Application Reference: 2025/0998

Site Address: 54 Pinehall Drive, Monk Bretton, Barnsley, S71

Introduction: Erection of a two storey side and rear extension and first floor rear extension

Proposed Rear Elevation.

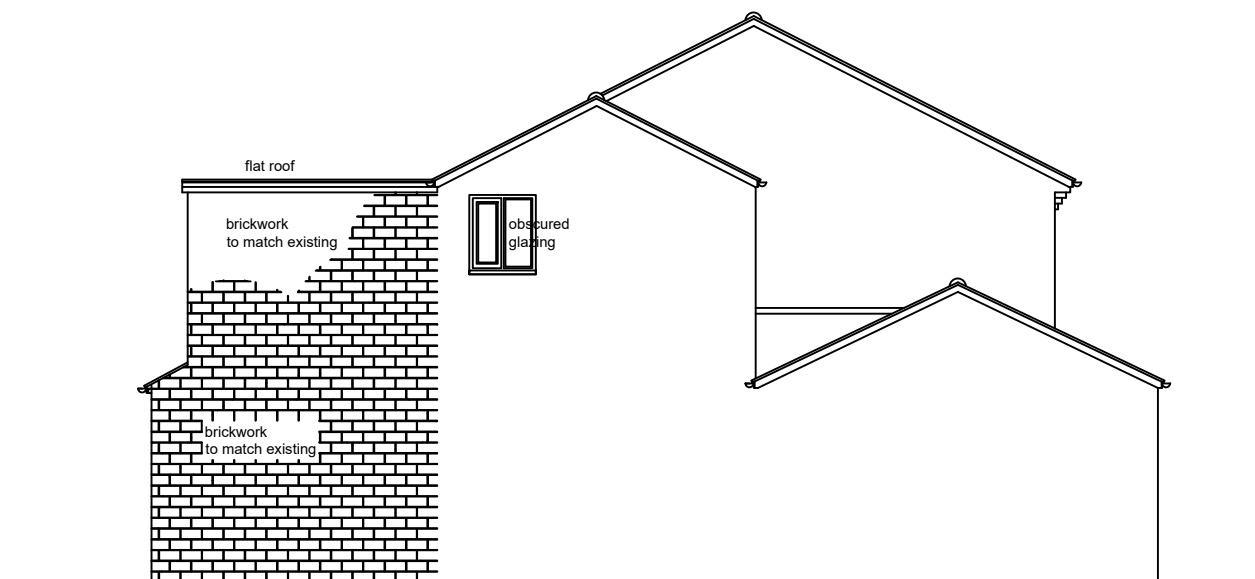
The proposed rear extension provides an acceptable rearward projection at first floor level of 3.5 metres. The proposal details a flat roof. Although a pitched roof would be preferred, given the proposal is to the rear and would impact upon the existing solar panels, on this occasion the flat roof is considered acceptable as it would not be detrimentally impactful on the street scene.

The proposed rear and side extensions would be erected to the south of 56 Pinehall Drive. The proposal provides an acceptable rearward projection of 3.5 metres. Although aesthetically a flat roof would not be preferred, the flat roof does on this occasion reduce levels of overshadowing to the north. The current proposed rear projection has been reduced allowing for a lessened impact on neighbouring properties. The proposed reduction also prevents any intersection with the 45 degree angle of the nearest neighbouring rear elevation window. It is acknowledged that the nearest neighbouring windows to the north would be impacted, however these windows do not service any habitable rooms and are already obscured glazing windows. The proposed side extension would be erected above an existing single storey side extension and provides a pitched roof. The ridge of the pitch has been reduced to 6.5 metres, reducing the dominance of the proposal. The impact of the proposal to neighbours to the north is therefore not considered to be detrimental to residential amenity.

The proposed rear elevation Juliet balcony would allow for some overlooking to rear neighbouring gardens; however the balcony could be installed without the need for planning

The proposed rear elevation glazing servicing an en-suite will be conditioned to be obscured glazing in order to protect the privacy of both the applicant and neighbours.

It has been necessary to make contact with the applicant to make amendments to the eaves height of the front elevation of the side extension, to provide a pitched roof for the rear extension and to reduce the rearward projection to 3.5 metres.

Amendments were received reducing the eaves height to match the existing front elevation eaves height. Amendments were received to reduce the first floor of the rear extension to 3.5 metres on the 20th January 2026.

The proposed side elevation window has been detailed to be obscured glazing and to service a bedroom. Although this would usually not allow for acceptable levels of outlook, given a window is detailed to the front elevation to service the bedroom, the room is considered to provide acceptable levels of outlook.

Proposed Front Elevation.

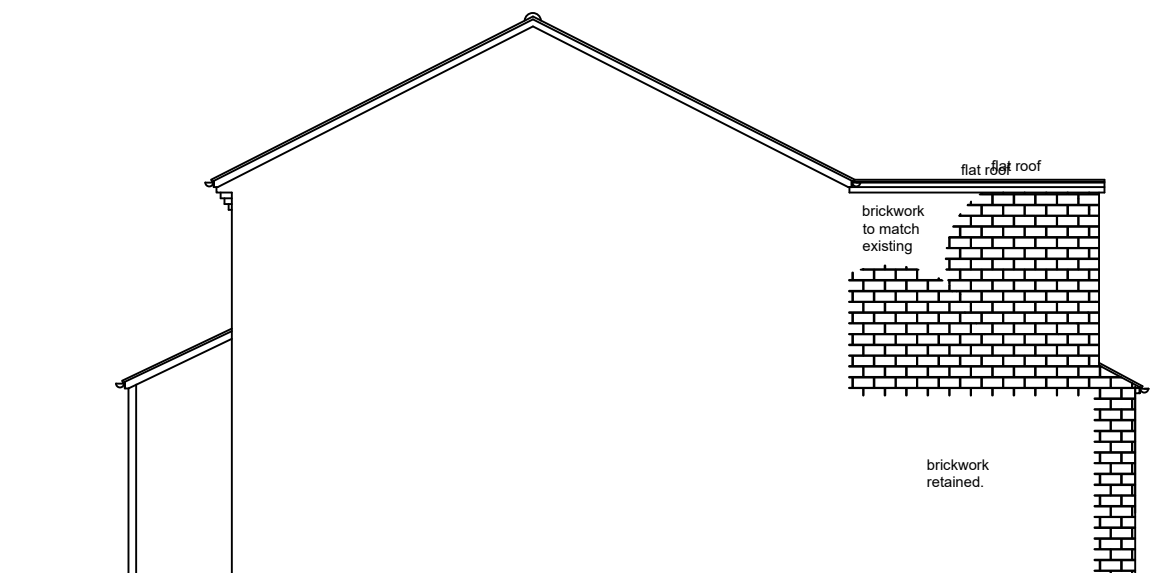
The proposed side extension provides an acceptable sideways projection less than two thirds the width of the existing dwelling. A pitched roof form is proposed providing a matching eaves height and a significant set down of the ridge, allowing the proposal to remain subordinate to the existing dwelling. The proposed side extension is also substantially set back from the front elevation of the dwelling, reducing its impact on the street.

All proposed glazing has been proposed with similar fenestration to the existing dwelling particularly the proposed window to the front elevation of the side extension. Matching brickwork and materials have been proposed which assists in allowing the proposal to remain in keeping with the character of the dwelling.
